BALLINA FLOOD RELIEF SCHEME

Compulsory Purchase Order No.01 of 2025

Case reference: ACP-323060-25

Plot Reference: T75-03

Drawing file: Application Documents / Owners_Occupiers Site Notice T75.pdf

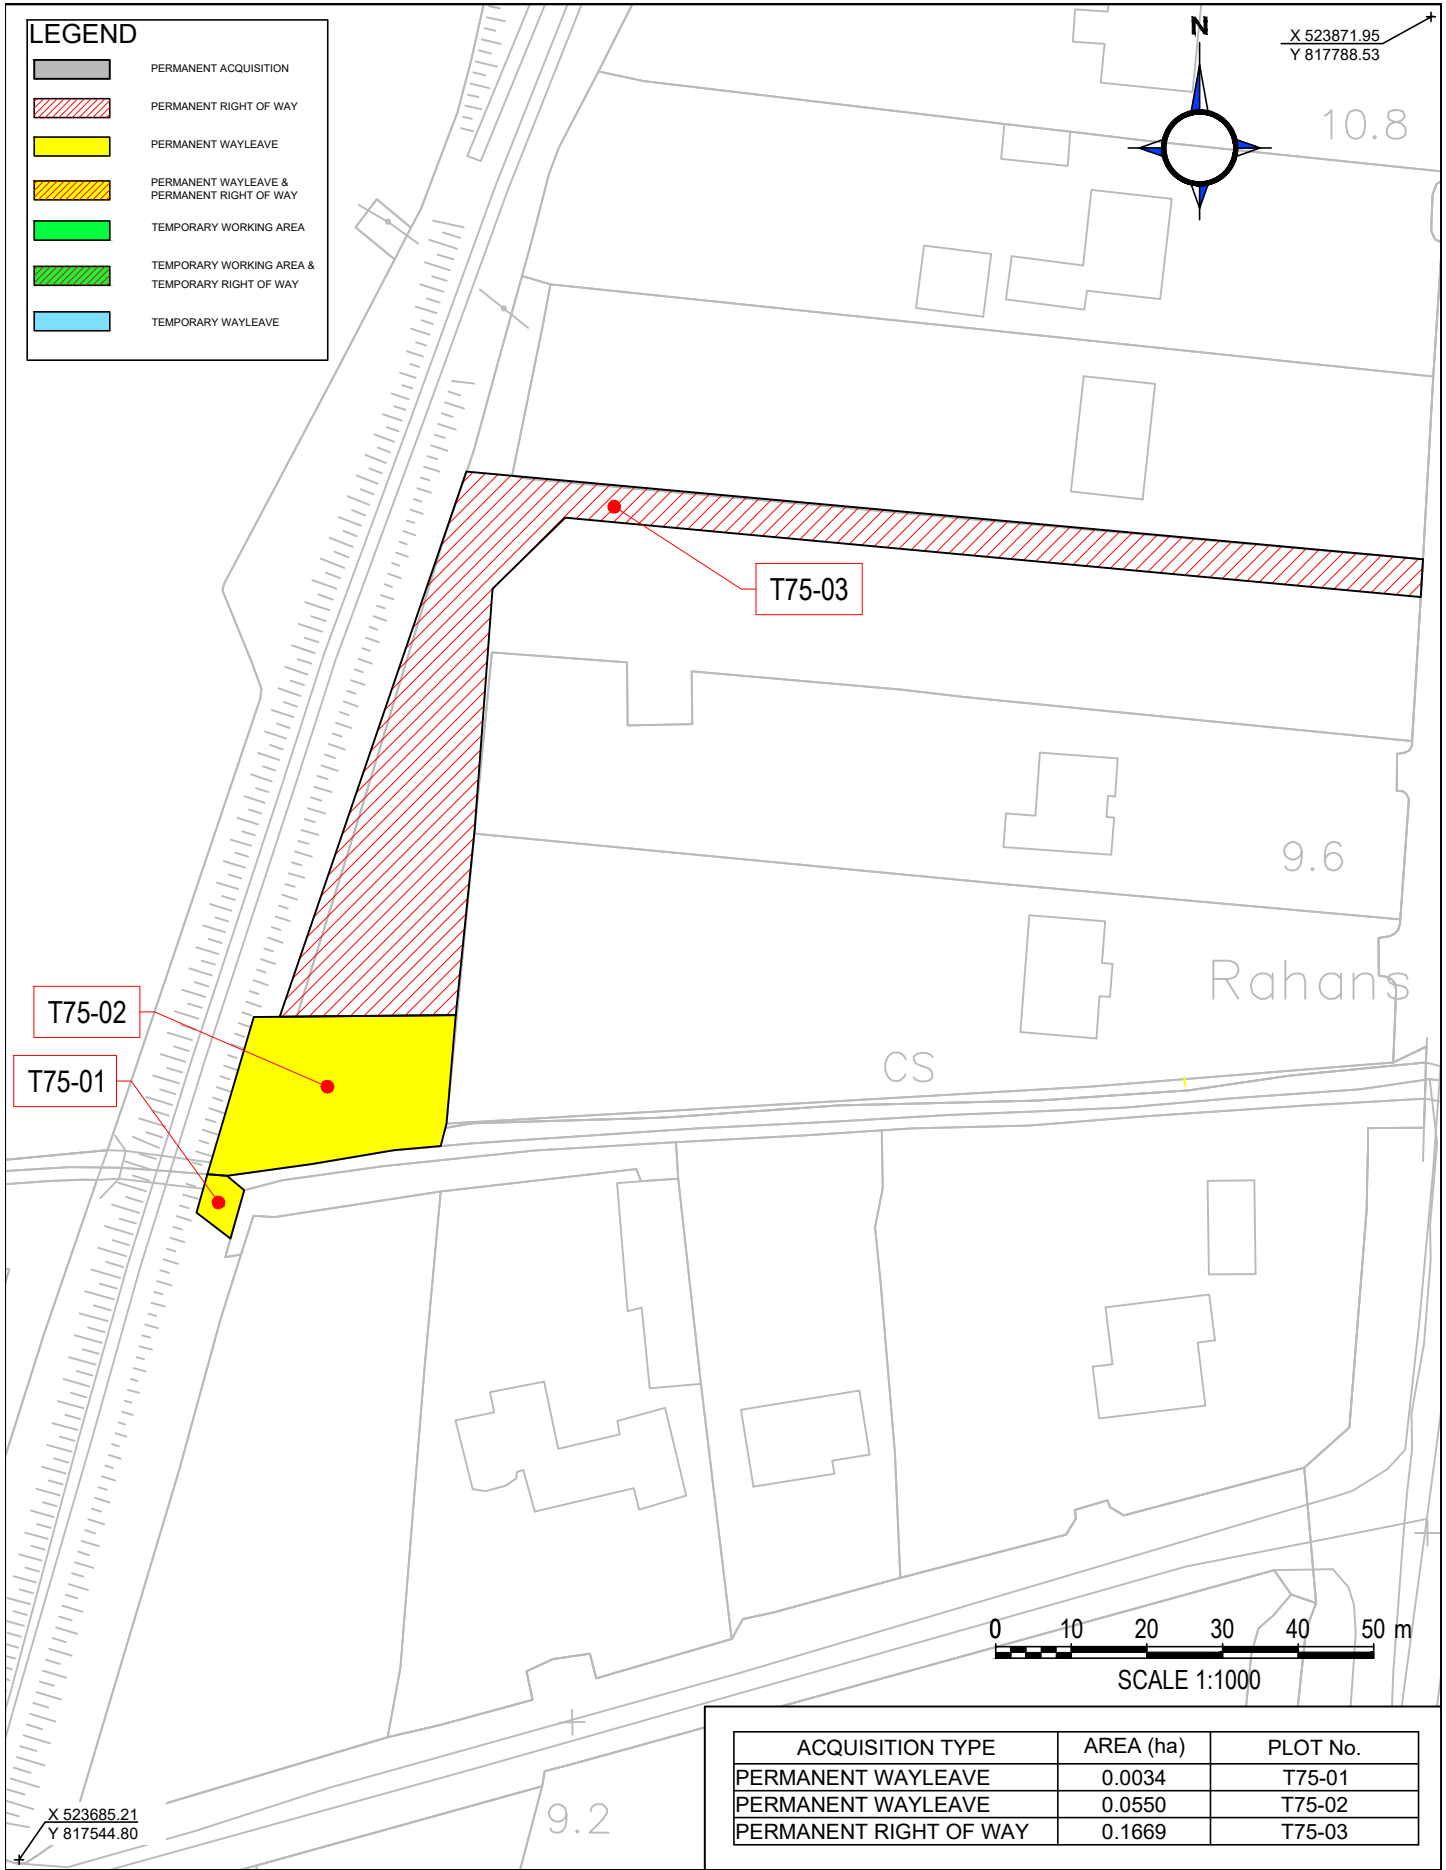
Drawing MGW0290-RPS-00-XX-DR-D-WL007-06

- Inadequate detailed information has been provided on what exactly is to be provided at the site.
- No direct consultation has taken place with myself, Marie Lavelle, either as the owner of an area of land affected by the CPO or indeed as a long-time resident in the area.

- The provided access route is aligned along the boundary of my site and causes issues in terms
 of overlooking and the security of my home.
- No detail has been provided about the use of the lands after the CPO and how this future use will navigate the topography of the site.

- There is a lack of detail provided relating to the design of the proposed access, to the right of
 way, from the Foxford Rd. to the front of the site. Is this a vehicular or pedestrian route? and
 what effect will it have on the existing entrance to my house? which will be situated alongside.

- Inadequate detail has been provided on the type of boundary to be provided along the new CPO line.
- Poor consideration has been given to the subdivision of the area of land adjoining my residence. The right of way has been routed along the boundary of my residence. Therefore, this right of way bisects and disconnects the land from my house. This land was purchased to be an additional amenity to my long-term home. The location of this right of way will essentially deny me access to this area of land from my own home.

This right of way creates an undesirable long laneway along the length of my property and provides a gateway to a larger 'no man's land' at the rear of two derelict houses. This presents issues in terms of security and passive surveillance of my home. Laneways are discouraged in the county development plan, and no details have been provided as how access to this area will be managed.

No drainage details have been provided along the permanent right of way, and where this area will drain to. No details have been provided as to the type of paving etc. to be provided on the right of way.

This proposed right of way will discharge on to a public path and a busy road. Again, how will access be managed to this right of way? will it be pedestrian or vehicular access? As this right of way runs the length of my boundary, the rear of the house and the back garden will no longer enjoy the privacy and security that I am accustomed to. I have concerns that the security and the privacy to the rear of my home will be seriously compromised if this right of way is established.

No detail has been provided about the use of the lands after the CPO and how this future use will navigate the topography of the site. Will substantial earth works be required? how will this affect both my home, the surrounding drainage and the remaining area of land, left after the establishment of the right of way?

The house directly beside the stream (indicted as D1), it is proposed it will have permanent wayleave along the side of the house, right at the stream boundary. It makes more sense to have access here. The ground is level and flat with a sizeable entrance to the site. The distance would only be approx 25 metres to link to the permanent way leave in comparison with the lengthy and unnecessary proposal across our lands. Please see photo 009.

Whilst Mayo County Council accepts that there will be an impact on the enjoyment of this existing residential property (Foxford Road, Ballina, Co. Mayo), arising from the potential creation of a permanent Right-of-Way on the adjoining lands, the local Authority has no further comment to make in relation to the proposals set out in the CPO for plot T75-03.

Mayo County Council is committed to further liaison with all impacted landowners during the design phase (Stage 3).
